**Consultation Response from KC,  
Conservation & Design**

**2025/93355 Land off, Woodward Court, Mirfield, WF14 0PY**

**Erection of 75 residential dwellings with associated landscaping, open space, highways and drainage infrastructure**

**Date Responded:25/3/26**

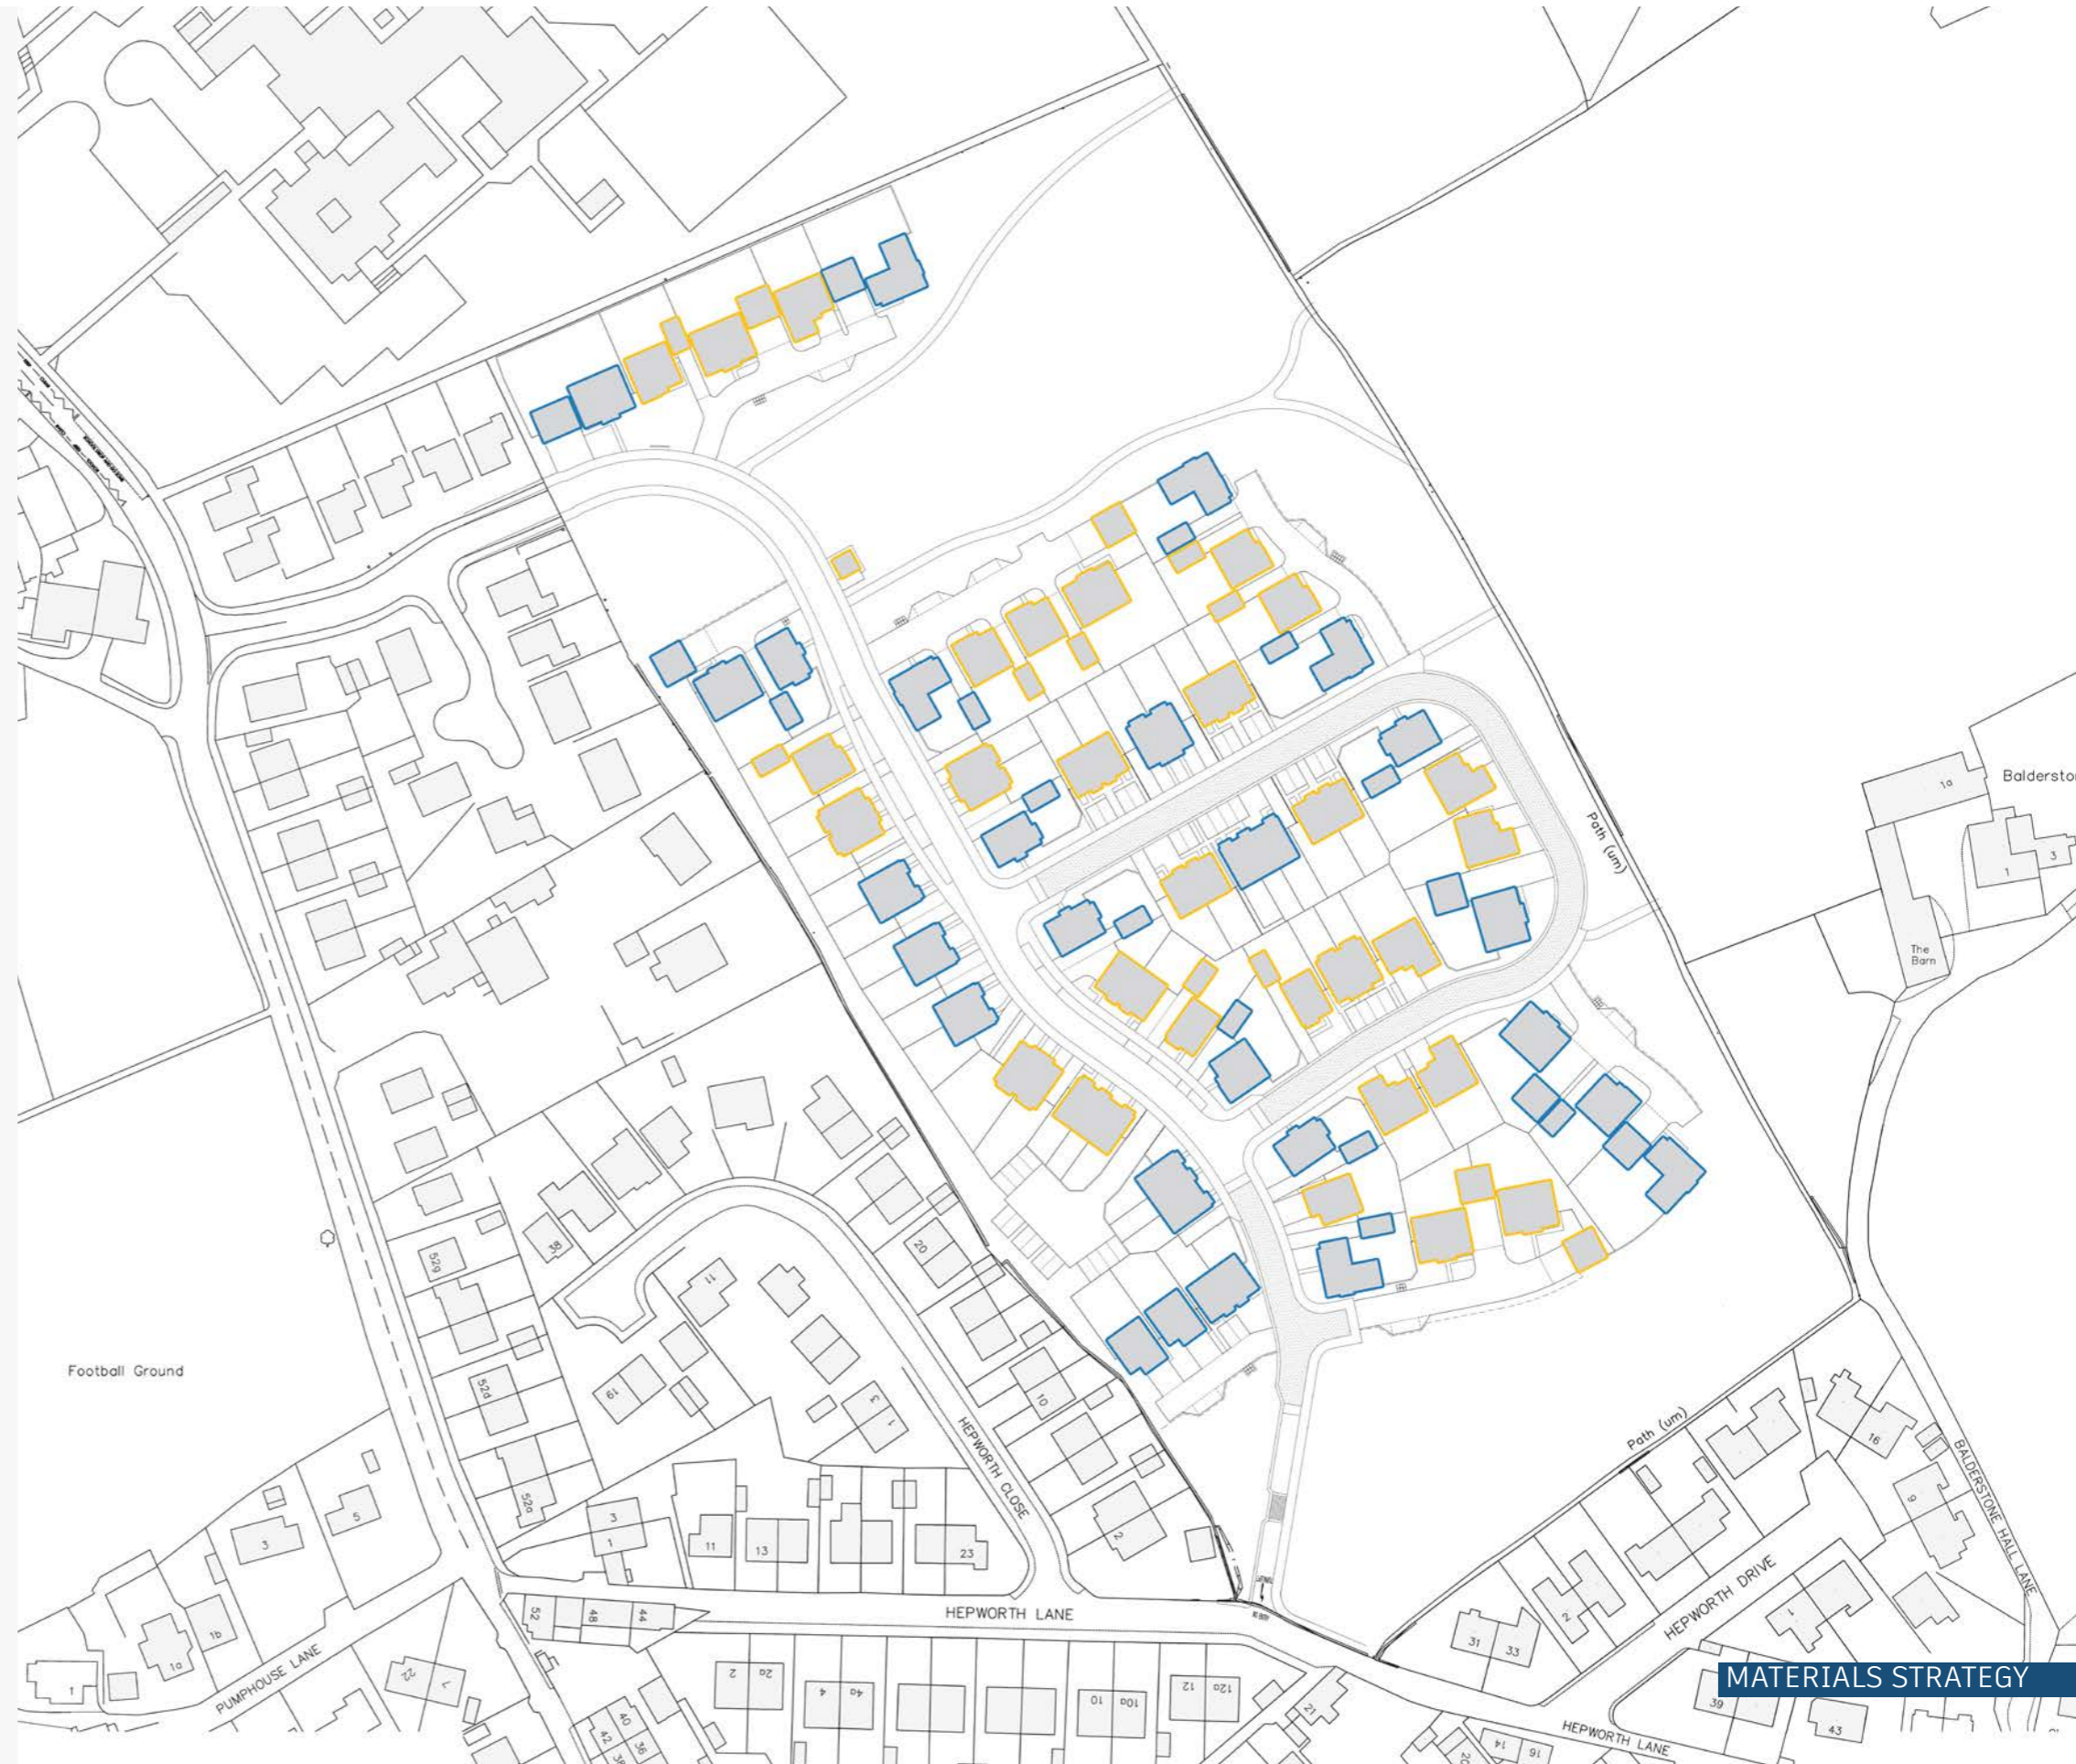
The submitted statement focuses on brick and red clay tiles, but Conservation Team consider that these materials do not contribute to the local distinctiveness of the area and if proposed at this site would cause harm to the setting of the listed buildings at Balderstone Hall.

The Materials Strategy at Section 4, P.66 indicates proposals for 2 types of red brick and grey concrete roof tiles. These materials are not appropriate in the setting of the listed buildings. Natural stone and slate should be used for dwellings within the setting of Balderstone Hall, and consideration could be

given to other buff coloured alternative types of masonry, and grey slate on the rest of the site.
